STATE OF NORTH CAROLINA
DEPARTMENT OF TRANSPORTATION

Addendum No. 2

RE: Contract # C204107

Cumberland County (U-4405)

PROJECT REFERENCE NO.	U-4405
SHEET NO.	UC-26
DESIGNED BY:	AMH
DRAWN BY:	AMH/AB
CHECKED BY:	AMH
APPROVED BY:	MWF
REVISED:	
NORTH CAROLINA DEPARTMENT OF TRANSPORTATION UTILITIES ENGINEERING SECTION PHONE: (919) 707-6630 FAX: (919) 250-4151

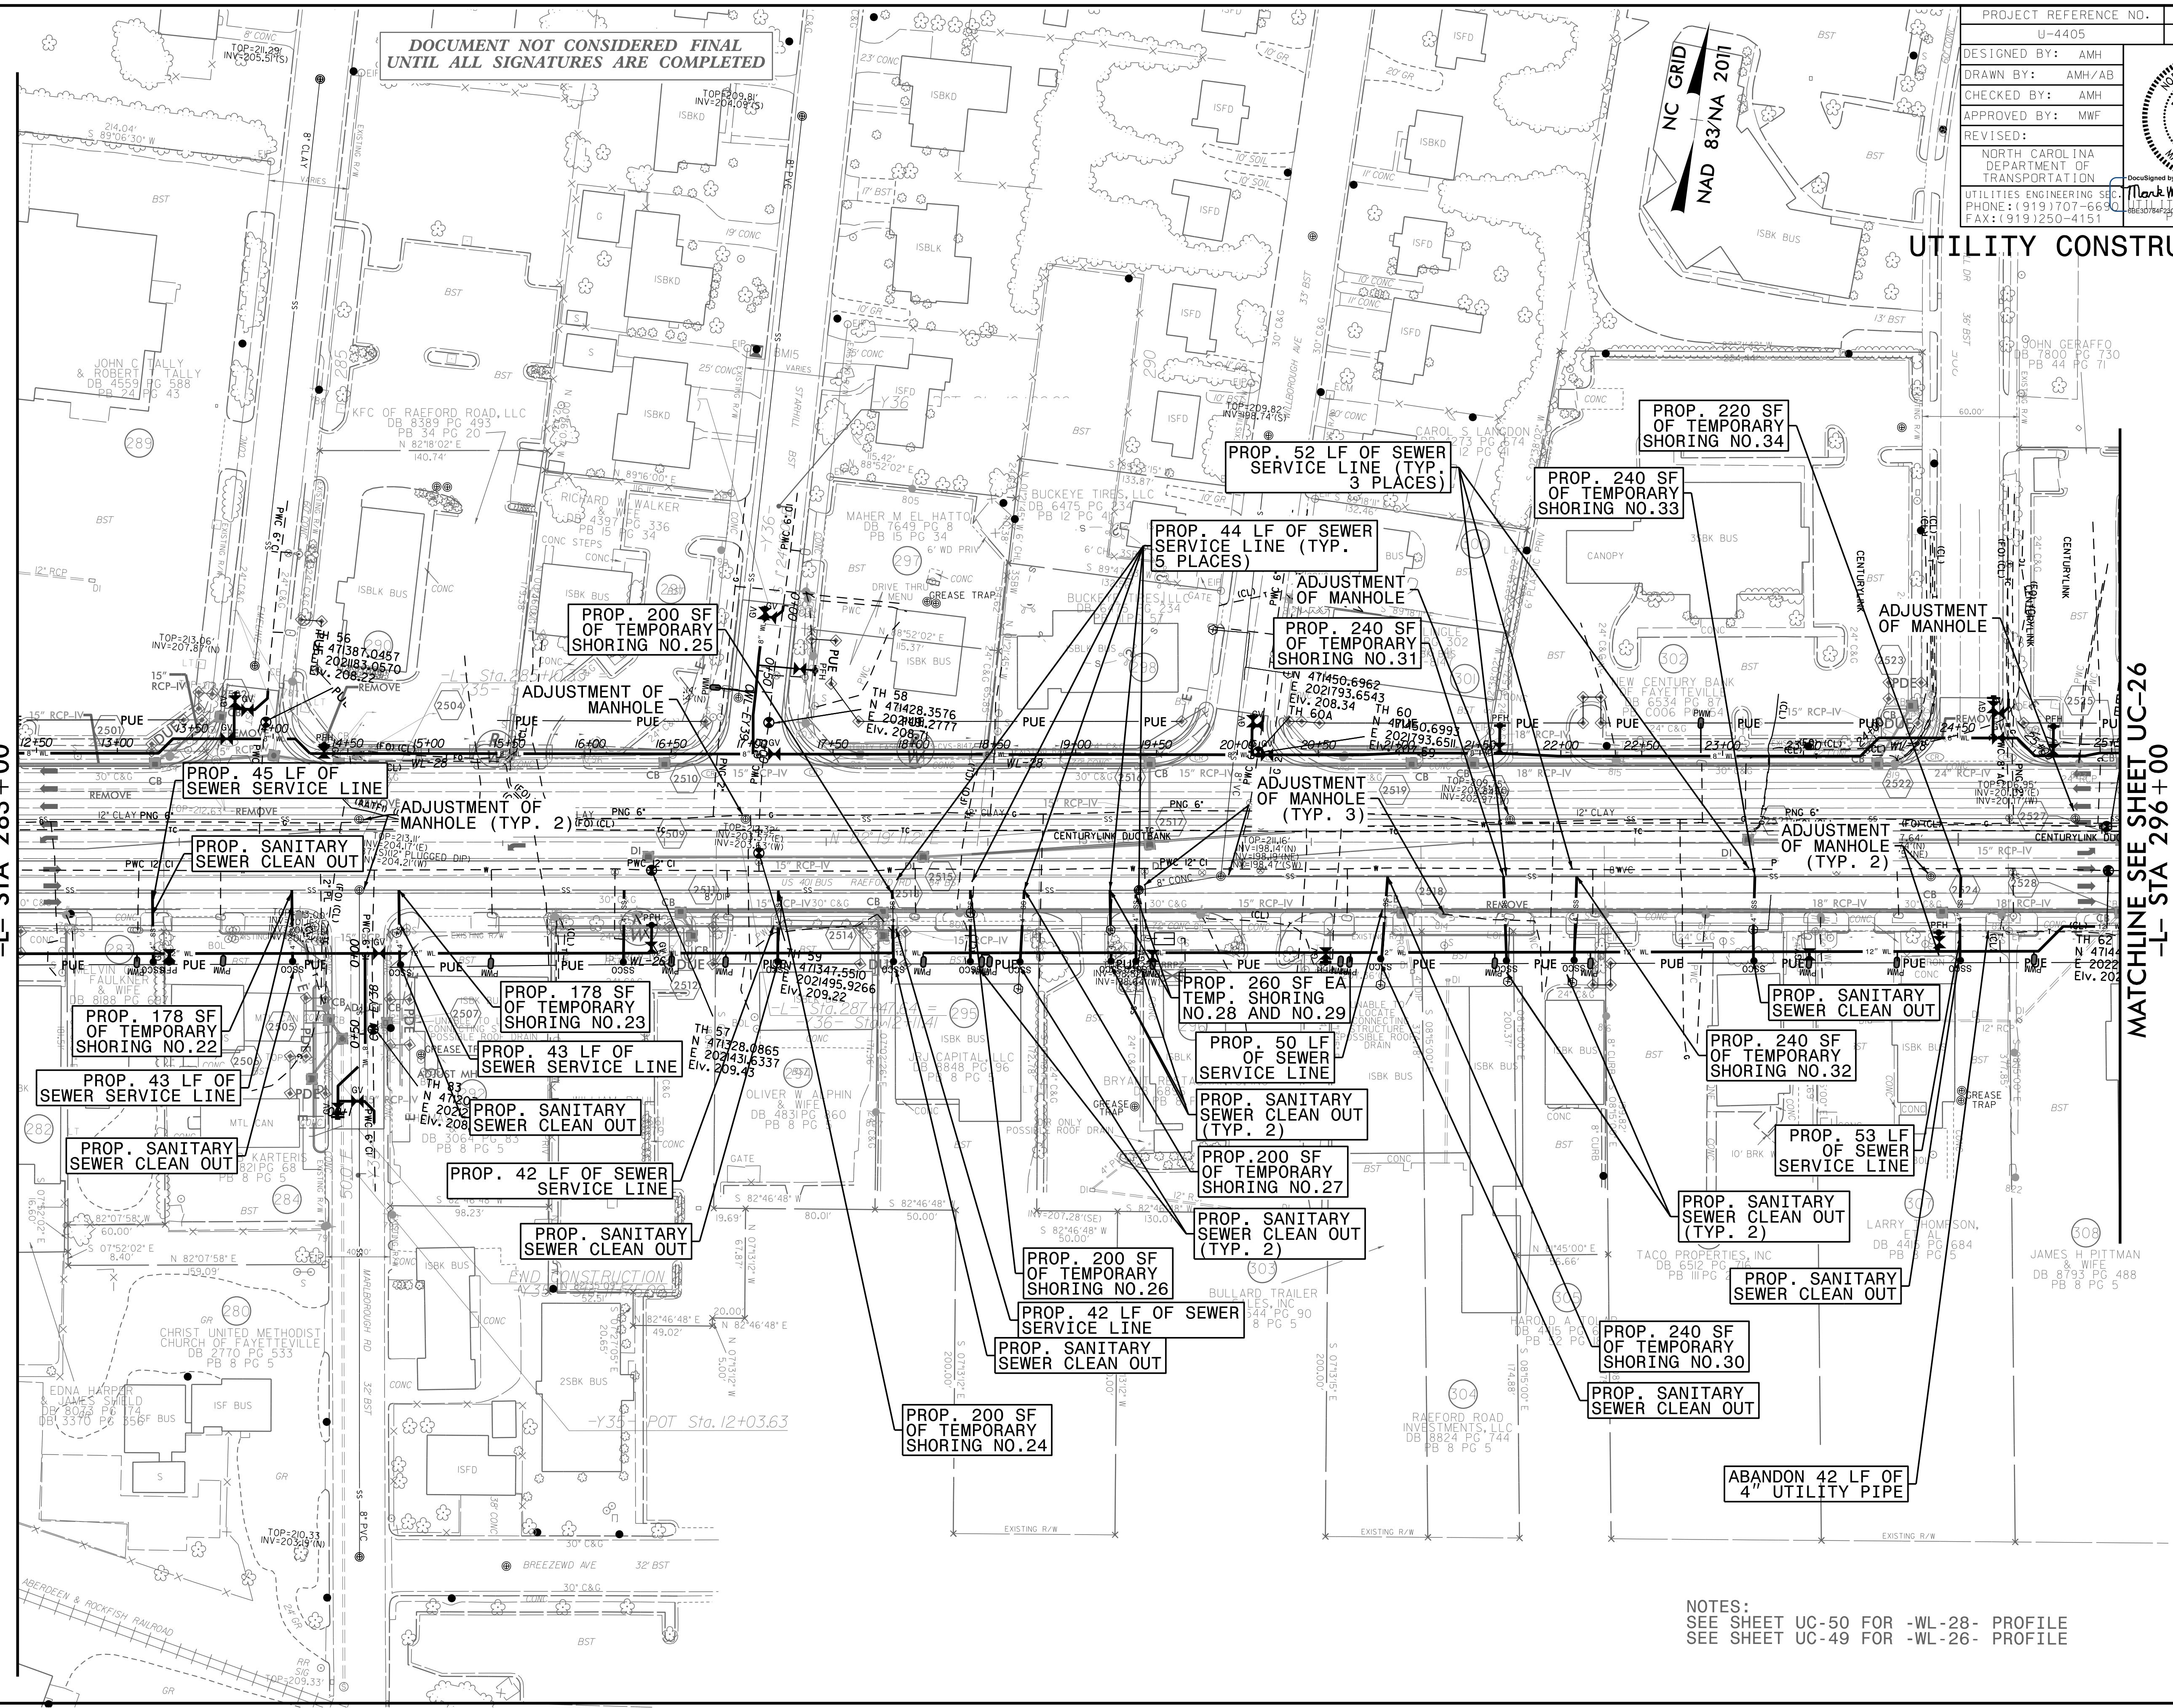
UC-23	Shifted valve on -WL-20R2- to Sta. 78+38.35; added killout symbol on Owen Drive; relocated valve from Owen Dr. to WL-23; revised proposed waterline type from 6" to 8" and added temporary shoring to Bore and Jack of 16" across McPherson Church Rd.
UC-23A	Added note to abandon 290 LF of 8" utility pipe
UC-24	Moved tie-in on Ancestry Drive out of the railroad ROW; added callout referencing next-in-line valve on Cambridge Street; revised callout for the length to nearest valve on Fairview Dr. to 760 LF
UC-25	Shifted two valves on WL-28 to Sta. 19+62.50 and Sta. 24+22.49
UC-26	Added an 8" valve to WL-28 at Sta. 27+21.85 and a 12" valve to WL-26 at Sta. 30+63.86

PROJECT REFERENCE NO.	U-4405	SHEET NO.	UC-26A
DESIGNED BY:	AMH		
DRAWN BY:	AMH/AB		
CHECKED BY:	AMH		
APPROVED BY:	MWF		
REVISED:			
NORTH CAROLINA DEPARTMENT OF TRANSPORTATION		6/12/2018	
UTILITIES ENGINEERING SECTION		CONSTRUCTION PLANS ONLY	
PHONE: (919) 707-6630		FAX: (919) 250-4151

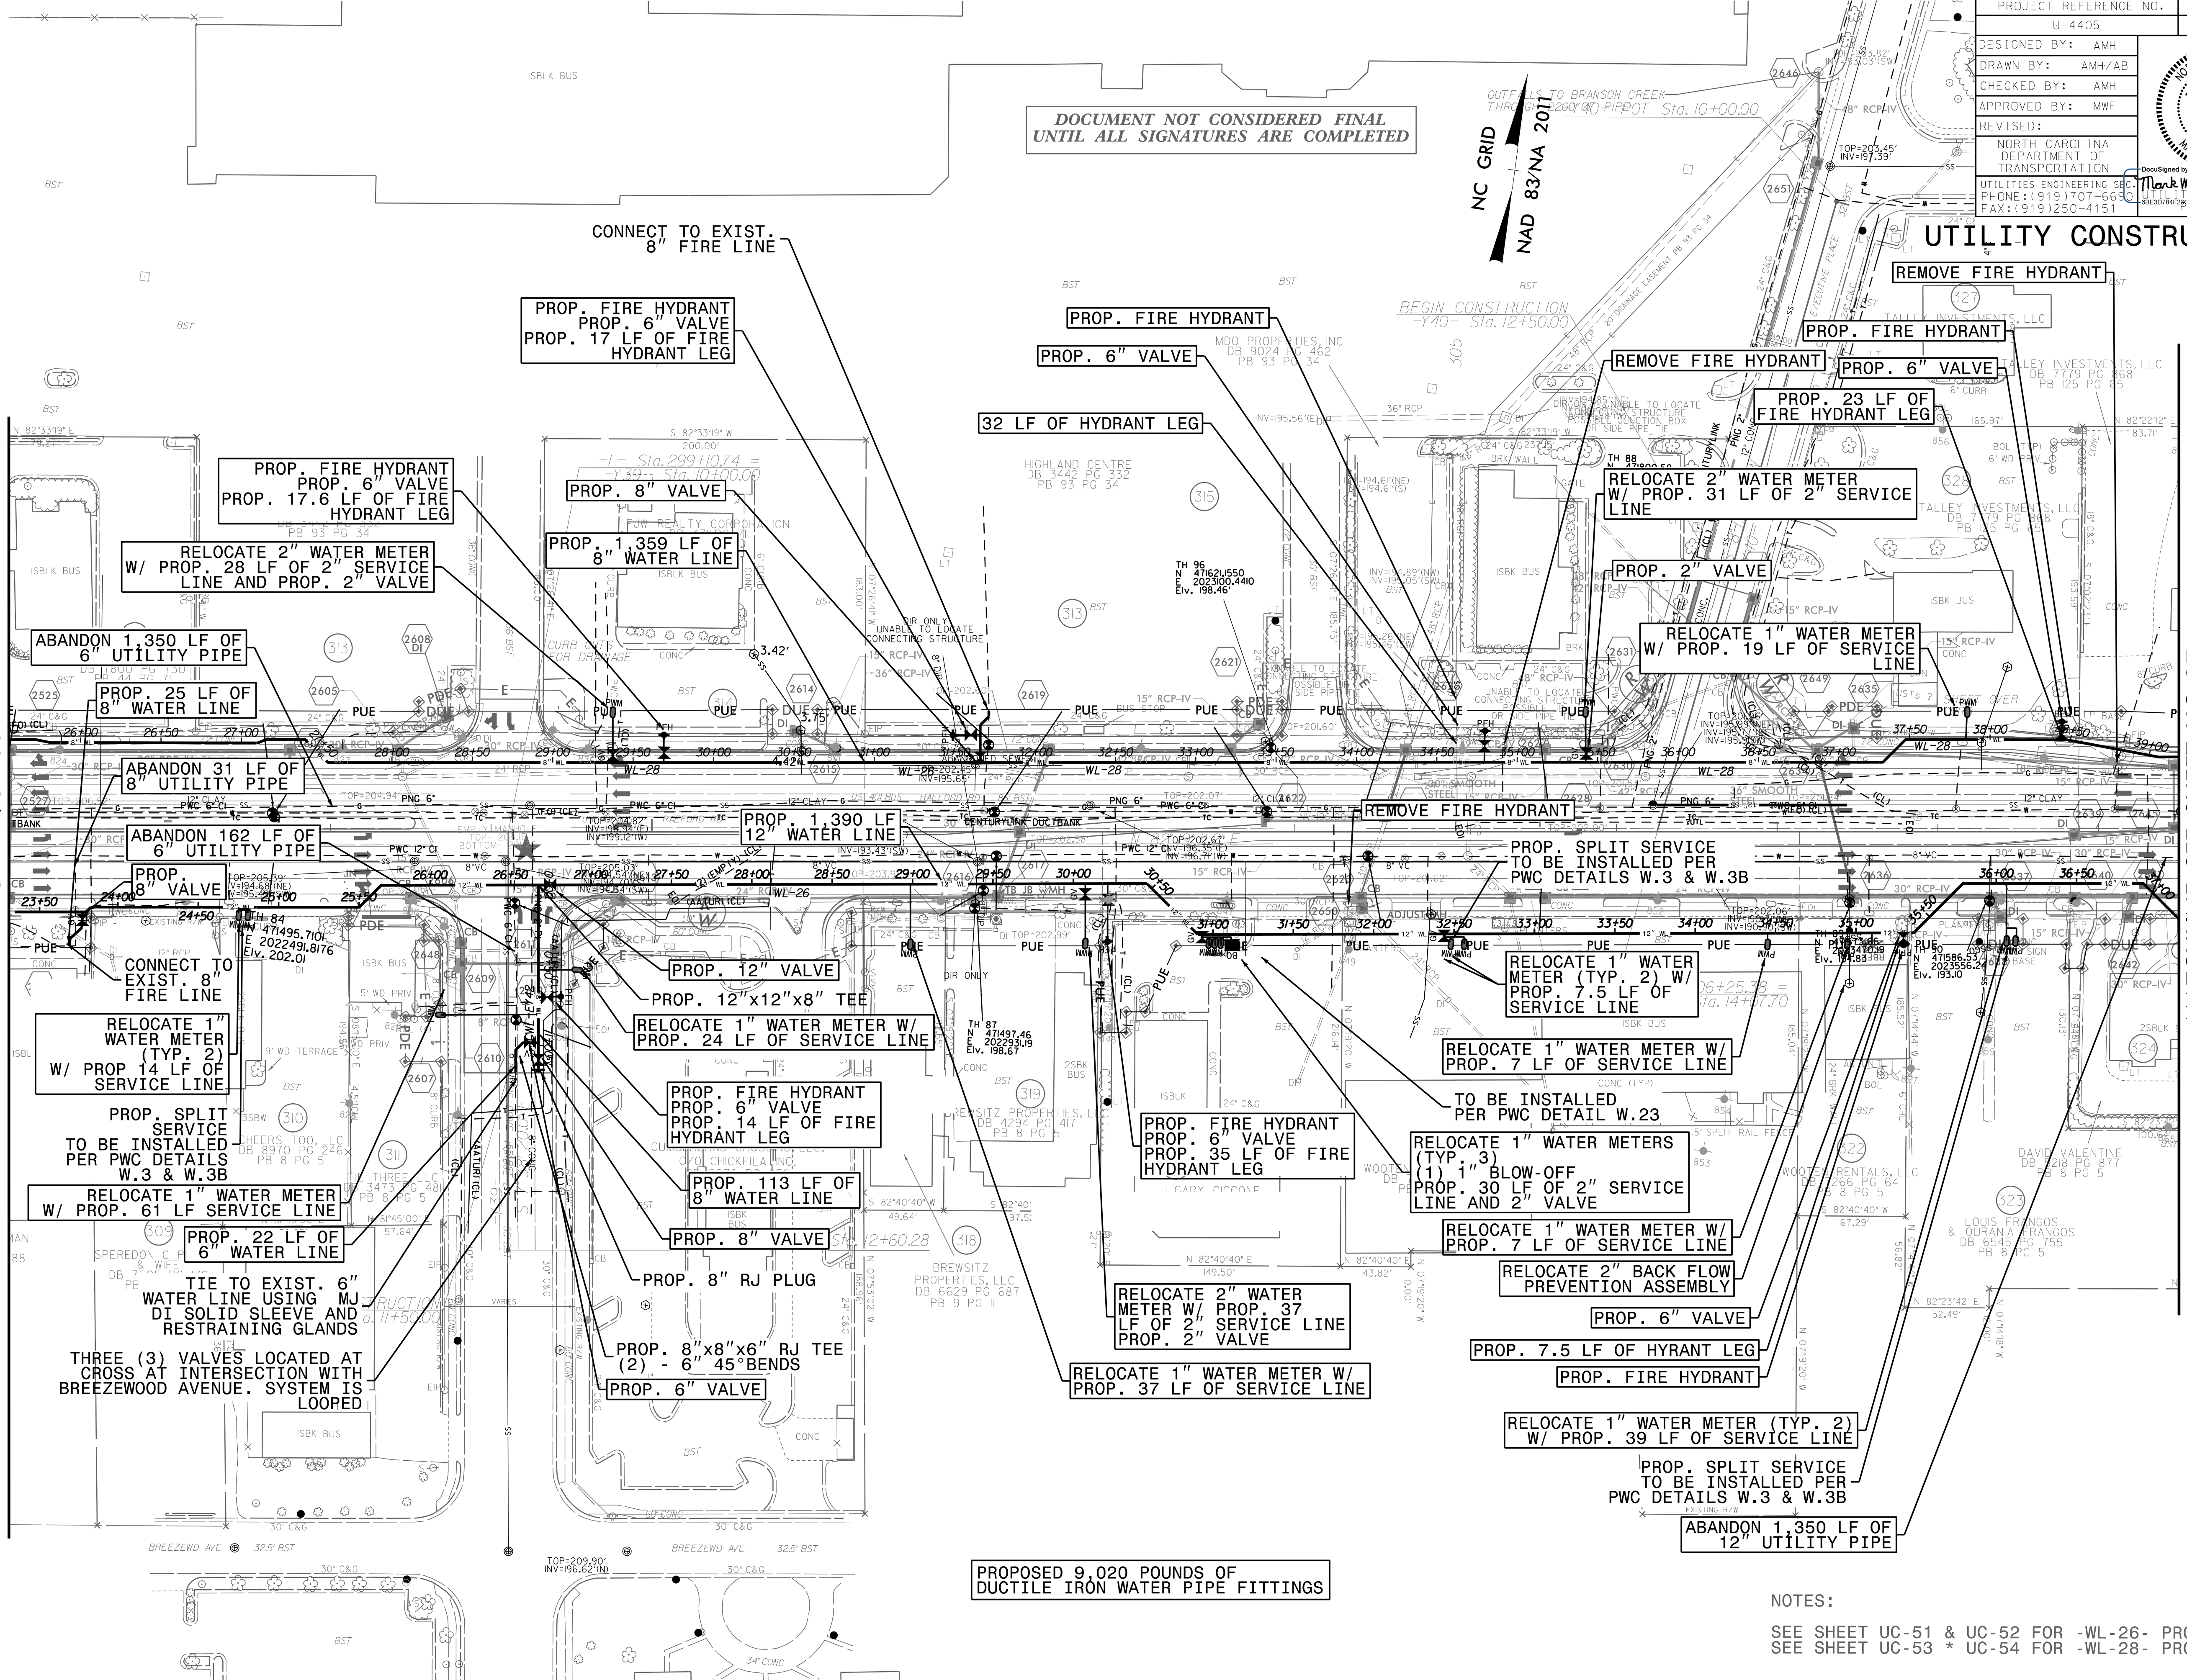
UC-26A	Corrected callout for temporary shoring No. 39
UC-32	Removed proposed encasement across Robeson Rd.; added a cut-in valve to facilitate reconnections and added labels to existing valves for construction sequencing
UC-34	Restrained joint pipe size changed from 24" to 8" on profile-WL-3-
UC-35	Profile -WL-6- reduced landing gap size on "Prop 15" RCP" callout to avoid conflict with Raeford Rd. centerline
UC-36	Profile -WL-7- removed "56 LF of 24" Waterline callout; removed vertical line at Sta. 0+00.00 and reduced landing gap size on "90" LF of RJDIP" callout on profile -WL-8-
UC-37	Profile-W-10- added duct bank to profile near Sta 18+60 and revised profile to be installed at lower depth to avoid duct bank;
UC-38	24" encasement thickness was revised on -Wl-12-
UC-39	Added 50 LF of RJDIP near Sta. 10+50 on profile -WL-14- and revised 24" Encasement thickness on -WL-13-
UC-40	Profile -WL-14- fire hydrant moved to Sta. 24+96; revised pipe callout for directional drill to show 32" HDPE SDR9 and added encasement thickness to 16" encasement
